NSW RURAL FIRE SERVICE

Our reference: S08/0040
DA16102404406 PC

16 November 2016

Modification to Project Approval (MP 08_0167) – Belle O'Connor Street, South West Rocks

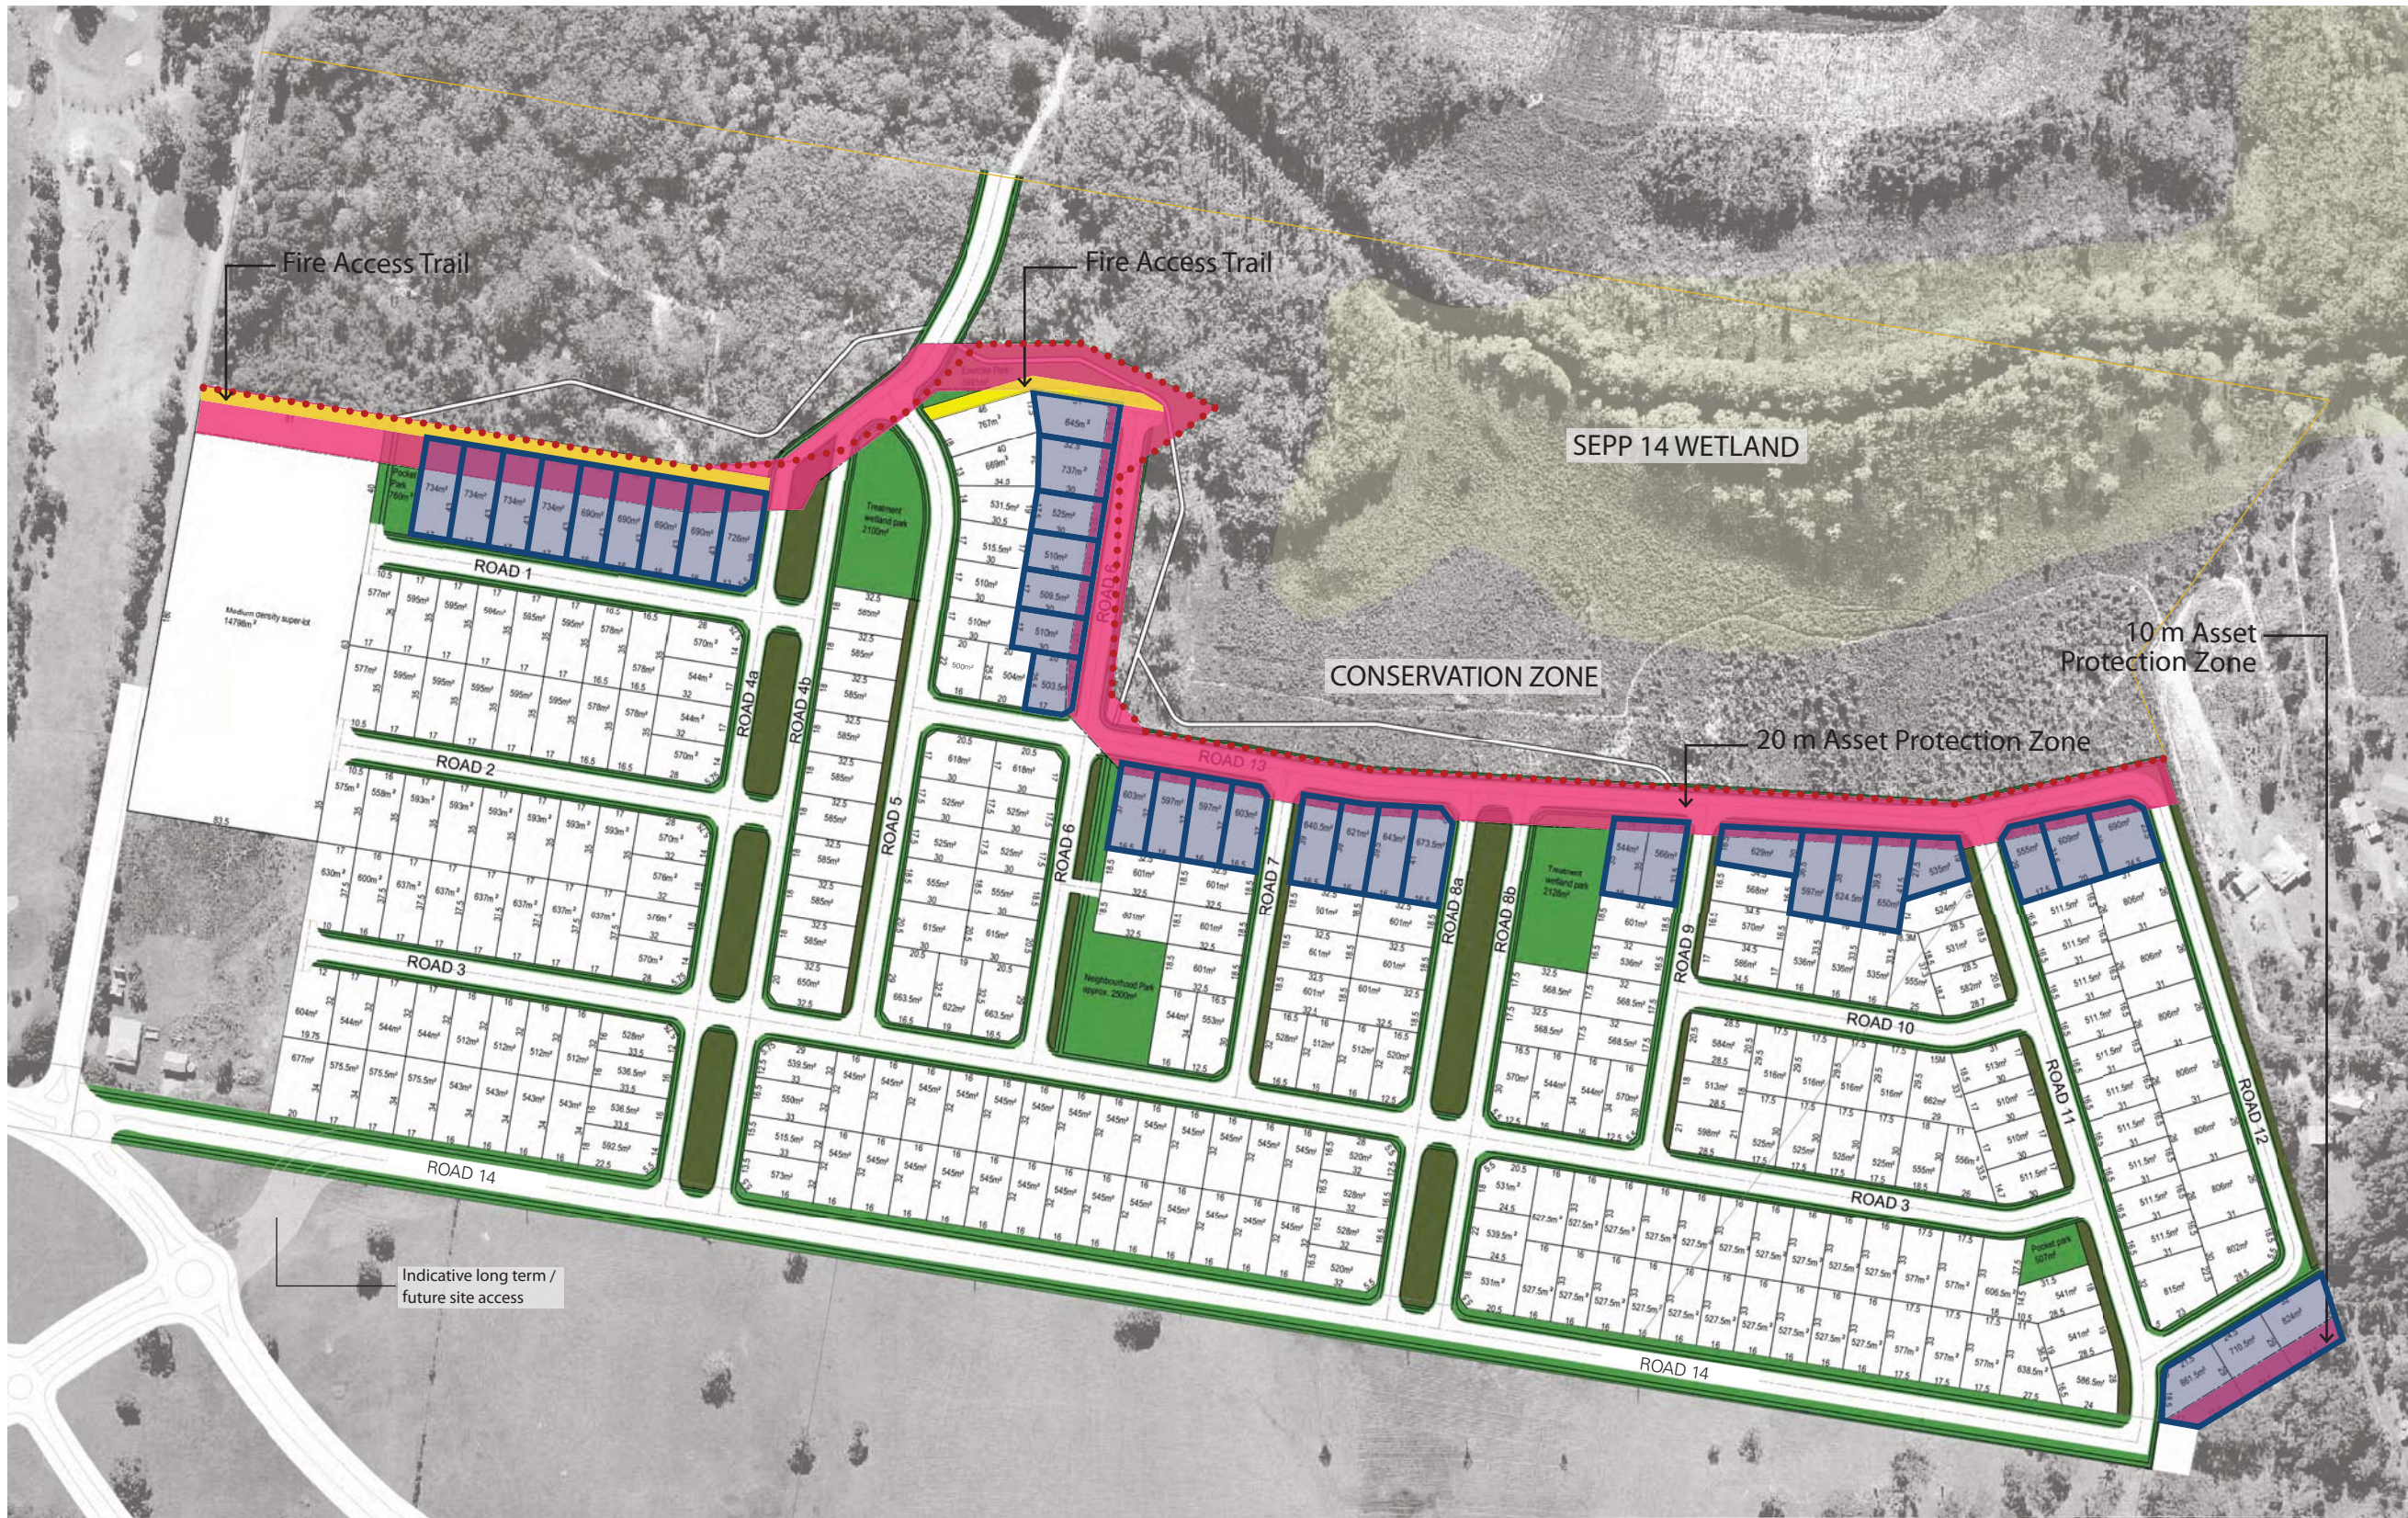
- The proposed plan of subdivision titled 'MP 08_0167 DA Modification' prepared by de Groot & Benson (ref: project No. 13056, Drawing No. L36-MP1, Amendment No. DA6) dated 12 July 2016 does not show the required asset protection zones or any reference to the fire trail previously approved along the northern boundary.

- The current Project Approval includes a fire trail along the northern boundary of Stages 10 and 11 which appears to have been deleted and replaced with a drainage easement. The preferred option to separate bushland from urban areas is a perimeter road and the application should demonstrate the benefit of the current proposal over the use of a perimeter road.

- The application should be amended to clearly show the location of the northern drainage easement with respect to access to the bushland interface. The extent of land that will be managed in this area should be detailed and the corresponding extent of asset protection zone that will be required on Lots 13 to 19.
